October 9<sup>th</sup>, 2024

Re: **La Foret Certification Letter  
El Paso County, Colorado**

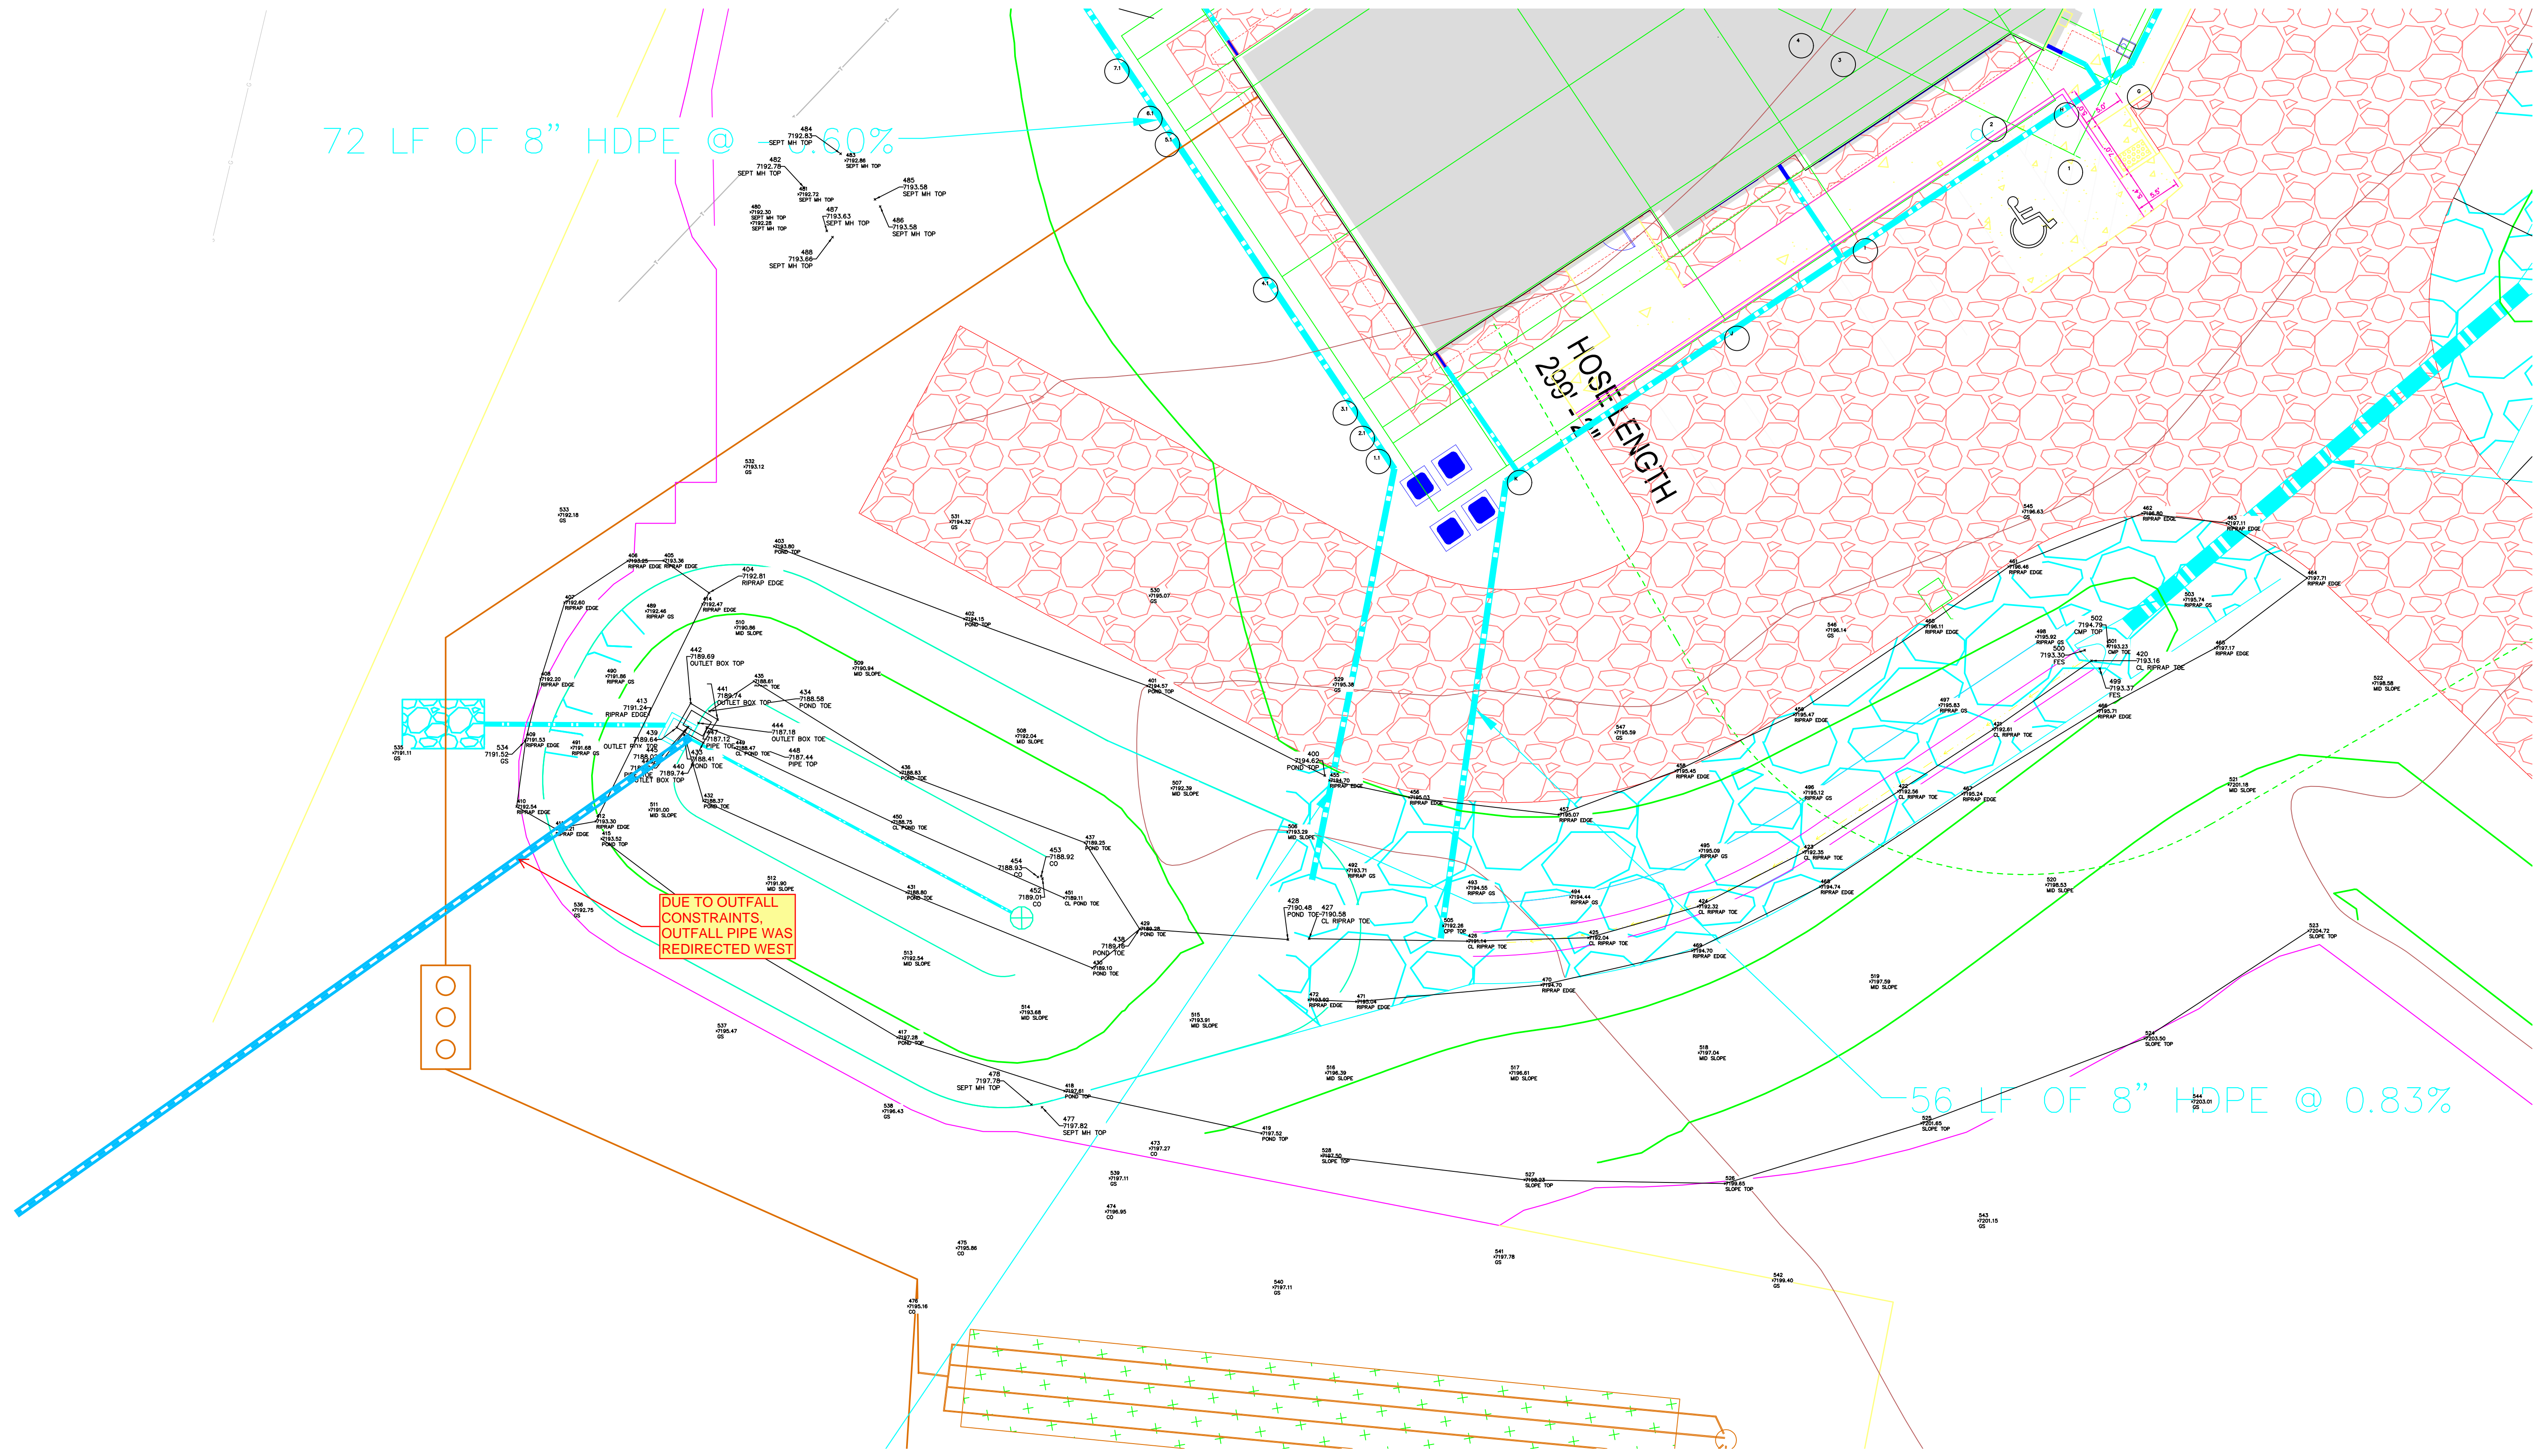
DUE TO OUTFALL CONSTRAINTS,  
OUTFALL PIPE WAS  
REDIRECTED WEST

Please show plansheet with changes and new shots overlaid - we need to get a better sense of the comparison between what was originally planned for and what changed.

Noted, original plan sheet now provided in appendix in order to provided comparison.

UD DETENTION SPREADSHEET FROM APPROVED FDR

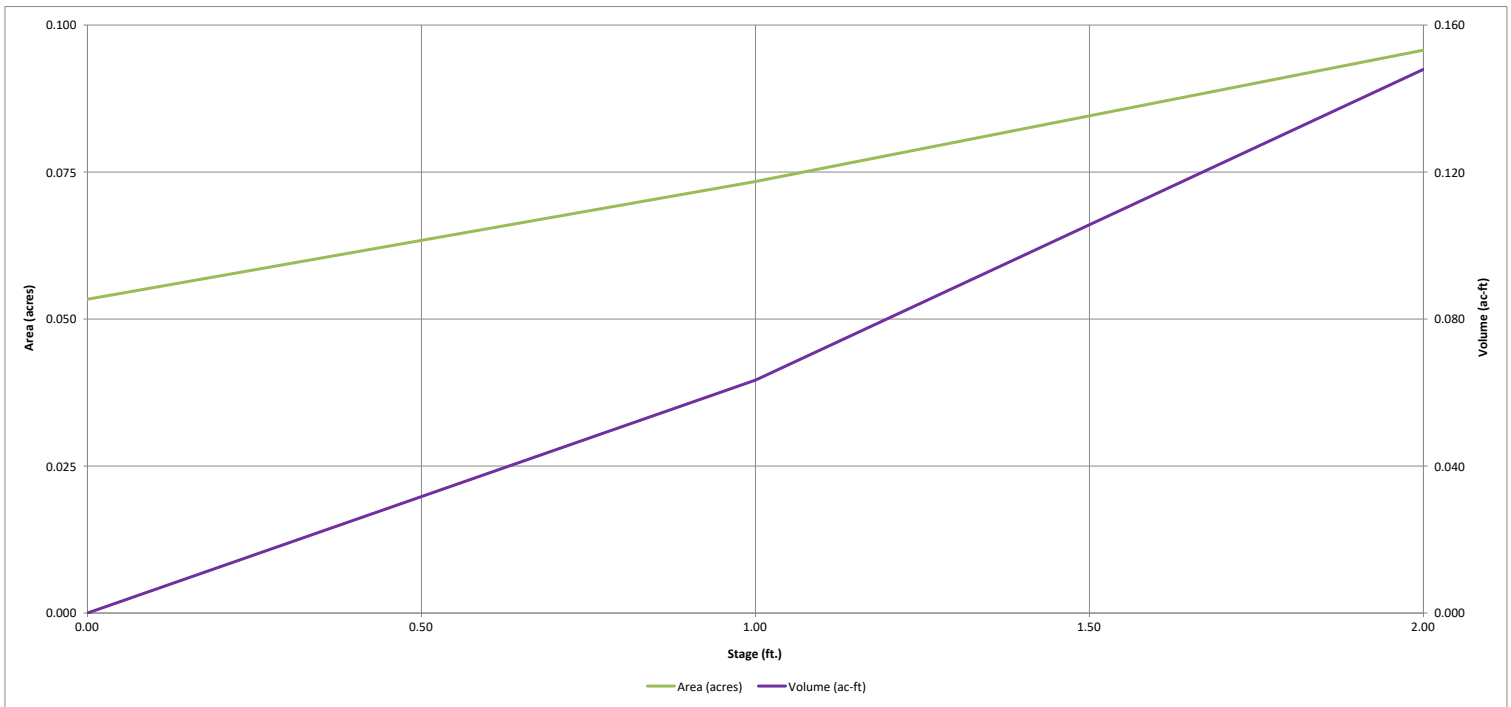
Please include the full MHFD-Detention Spreadsheet so drain times can be confirmed. Please update the MHFD-Detention Spreadsheet with the updated as-built information (pond elevations, spillway length, orifice hole elevations, etc.) to confirm that the pond is functioning as intended. The updated Spreadsheet should be attached to the Pond Certification Letter. If some items haven't change keep that as-is from the design calcs.

This spreadsheet is the revised UD Detention spreadsheet with updated as-built information. The revised spreadsheet confirms the drain times and that the rg is functioning as intended. The Original spreadsheet, as found in the approved FDR, has been provided in the appendix as well for comparison.
